The Sizewell C Project, Ref. EN010012

Compulsory Acquisition Hearing Part 2 (18 August 2021) – (CAH2)

Post Hearing Submissions including written summary of Suffolk County Council's Oral Case

3 September 2021

Plate 4.4: Sizewell Link Road

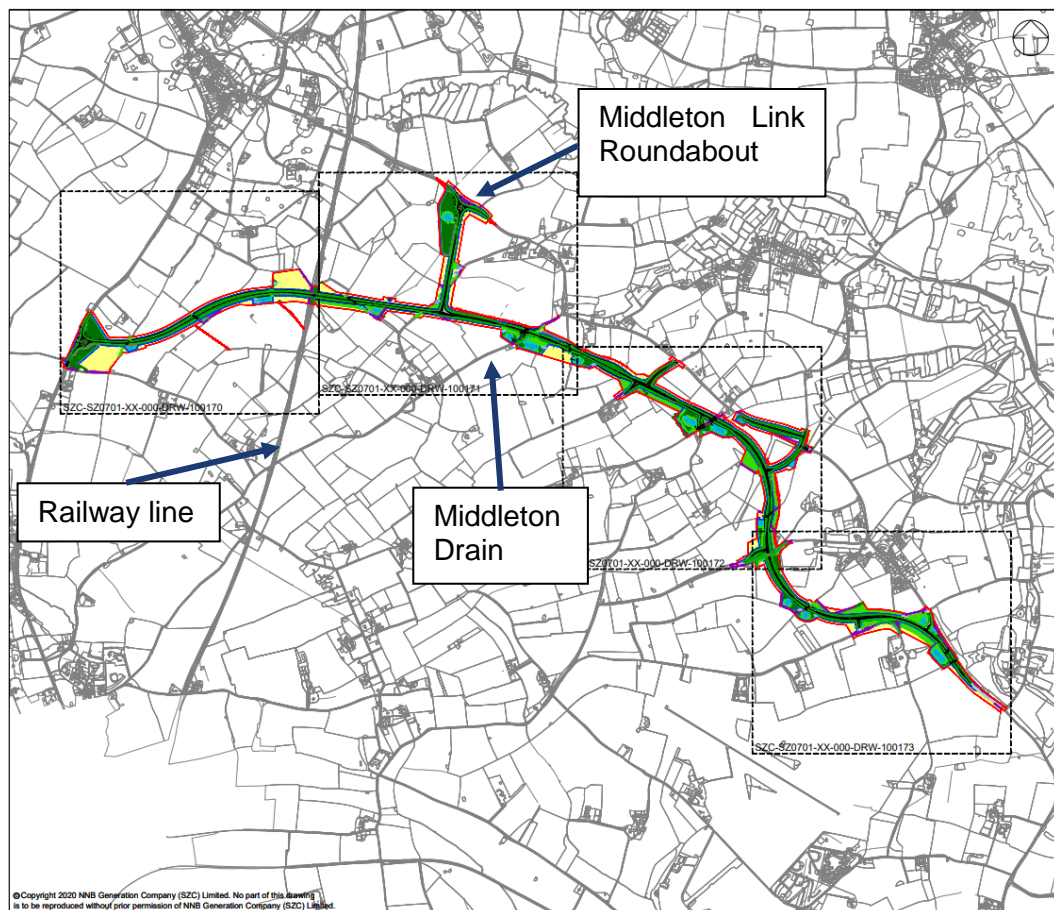
<p>authority in May 20021 for preliminary technical approval. This has yet to be reflected in the plans for approval.</p> <p>Several parts of the drainage for the SLR rely on connections between highway drainage lagoons and existing ditches or watercourses. In discussions with the applicant it was agreed that incorporation of these drains into the public highway was excessively disruptive to landowners and that a more appropriate measure was for the applicant to agree easements or wayleaves protecting the future highway access for the LHA.</p>	
Leiston Recycling Centre	<p>Leiston Recycling Centre is affected by the proposed realignment of Lover's Lane and associated changes to the access to the Centre. This important public facility serves a large catchment around Leiston, with the nearest alternative facilities being at Lowestoft to the north (approximately 35 minutes' drive), Foxhall, Ipswich to the south (35 mins) and Stowmarket to the west (50 mins).</p> <p>The Centre is safeguarded in the Suffolk Minerals and Waste Plan 2020, which is at Appendix 1.2 to the Local Impact Report [REP1-063]. The relevant policy (policy WP18) is set out in Table 5 on page 123 of the LIR [REP1-045]. It says:</p> <p>"The County Council will seek to safeguard existing sites and sites proposed for waste management use as shown on the Proposals & Safeguarding Maps and will object to development proposals that would prevent or prejudice the use of such sites for those purposes unless suitable alternative provision is made.</p> <p>Development proposals in close proximity to existing sites, should demonstrate that they would not prejudice or be</p>

Two Village Bypass and Sizewell Link Road drainage	Uncertainty remains regarding the drainage strategy and in particular the size and location of drainage lagoons as identified in the Request to Participate [REP6-050].	
Public rights of way:	As identified in the Request to Participate [REP6-050], Paragraph 3 of Schedule 10 in the draft Deed of Obligation should include an obligation on the Applicant to enter into any creation agreement required under section 25 of the Highways Act 1980 in respect of new or upgraded public rights of way within its ownership and a covenant that the Applicant will not seek compensation under section 28 of the Highways Act 1980 in respect of any use by SCC of its compulsory powers for creation of footpaths, bridleways and restricted byways under section 26 of the Highways Act 1980 on land within the Applicant's ownership. See SCC's submission at D5 on the draft Deed of Obligation [REP5-179].
